Development Facilitation Team (DFT) – Review Comments

Project No: PR-2020-003259 Date: 02/26/2025 Agenda Item: #2 Zone Atlas Page: B-17, C-17

Request: Preliminary/Final Plat Application for Honeywell

Location: 9201 San Mateo Blvd NE

SECTION 5
120

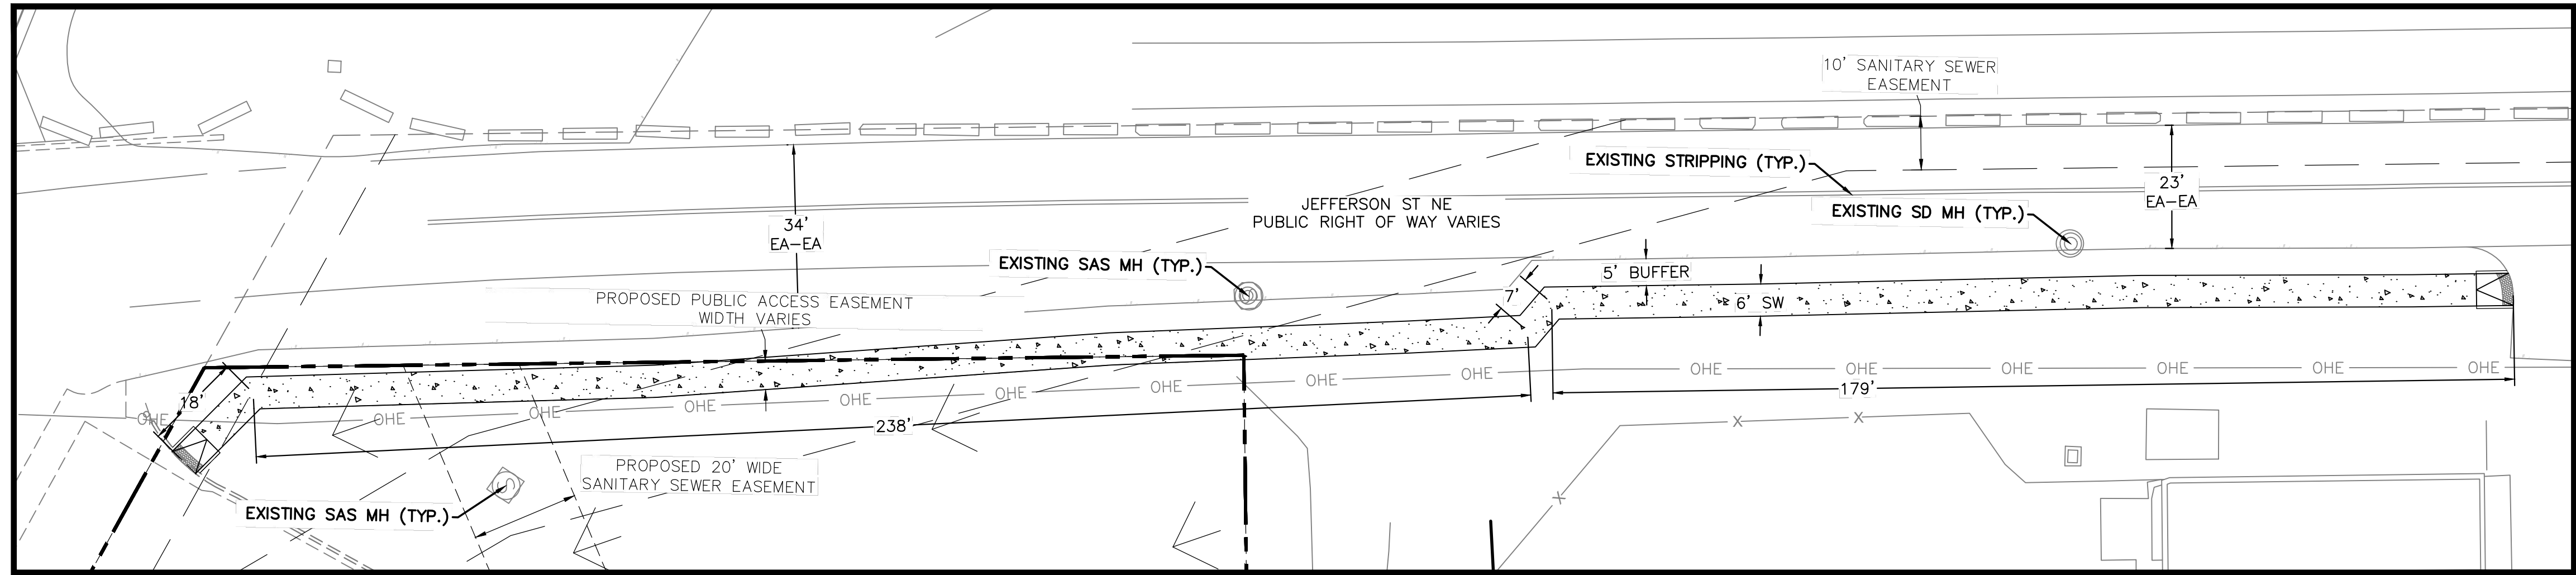
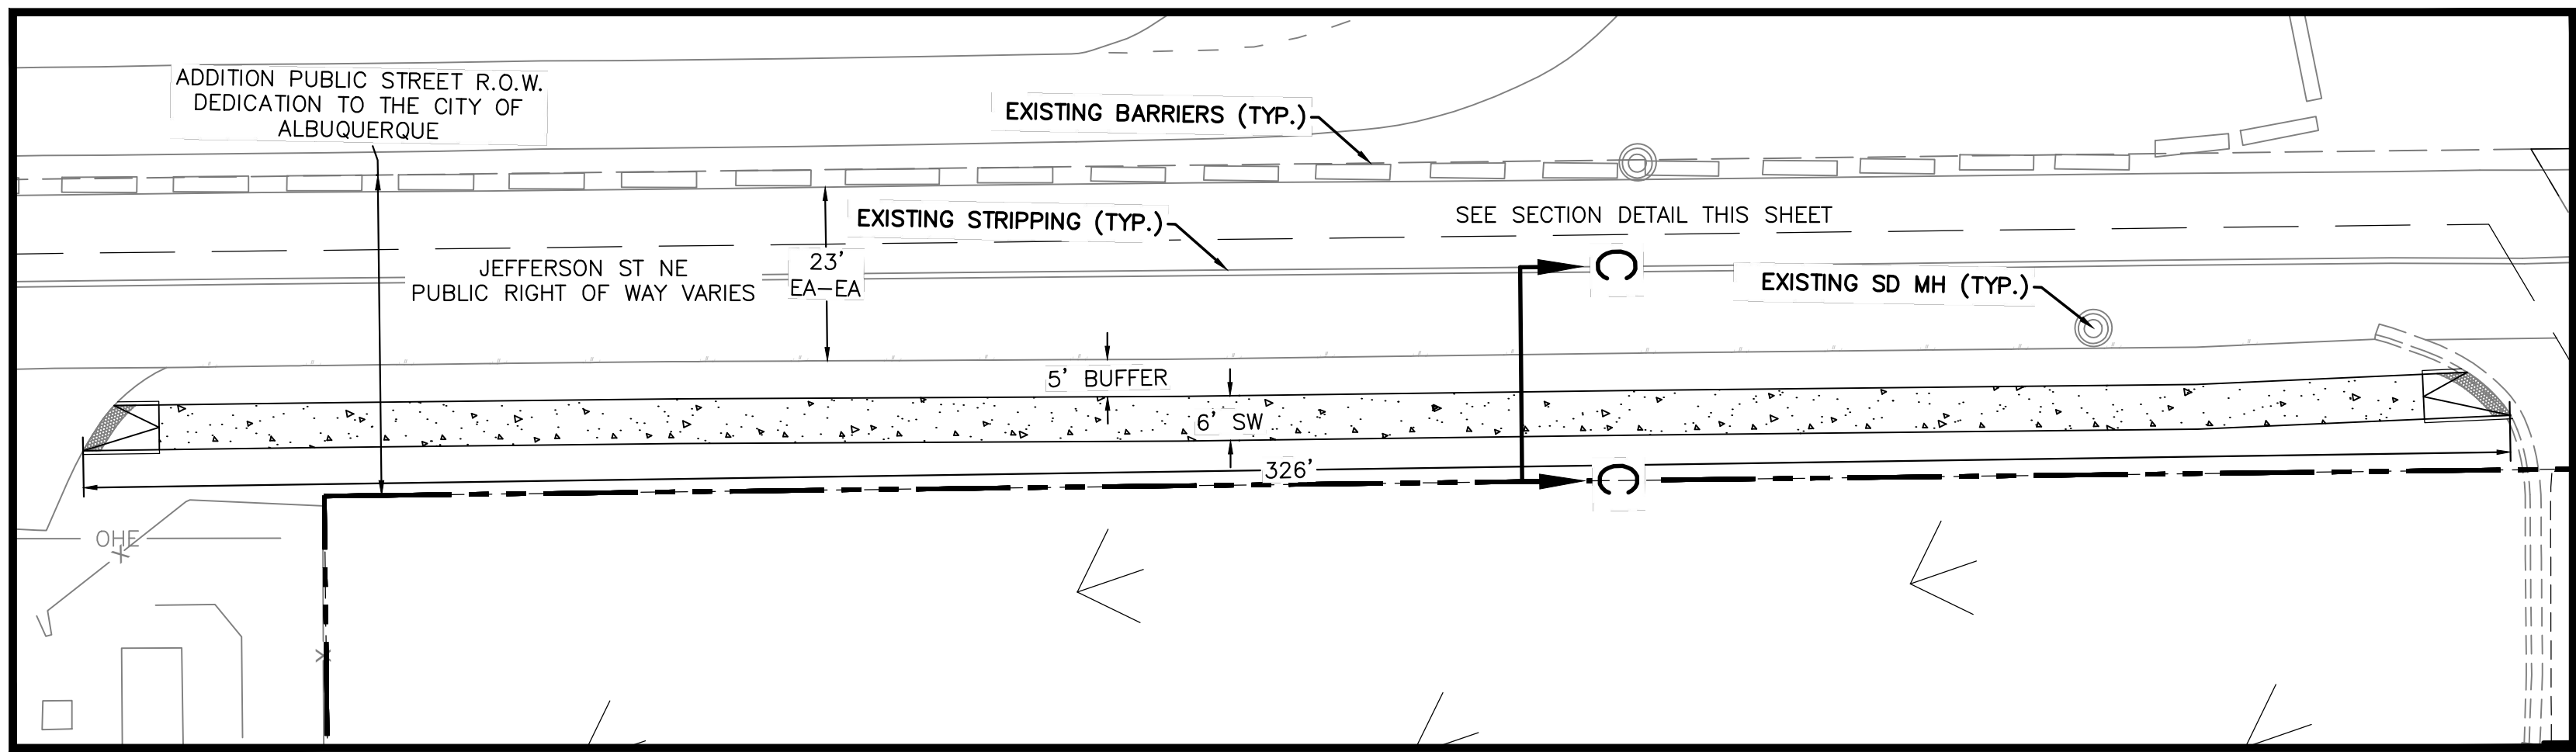
1. Transportation has an approved Conceptual TCL dated 6/25/2024.
2. Your plat has ROW dedication along San Mateo for proposed sidewalks, but is only proposing sidewalk easement for Jefferson. Is there a reason for this? The City prefers dedication over easements.
3. All work within the right-of-way and in public easement needs to be placed on an infrastructure list and financially guaranteed. This work will be done under City work order.
